STOP WORK NOTICE

July 27, 1999

RE: 170 Wayside Rd
CBL: 182-F-005

170 Wawwise Rd

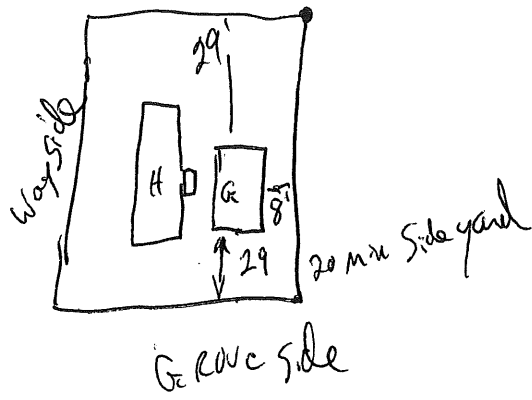
An evaluation of the property at 170 Wayside Rd on July 27, 1999 revealed that the structure fails to comply with Section 111.3 of the 1996 BOCA Code of the City of Portland.

Failed to meet proper setbacks on site.

Therefore, you are required to submit amended construction and site plans to this office for review and approval. You must also submit a list of all subcontractors on the job with their addresses and telephone numbers. When you have received approval of the amended plans and submitted the requested subcontractor information you may request removal of the "STOP WORK" order.
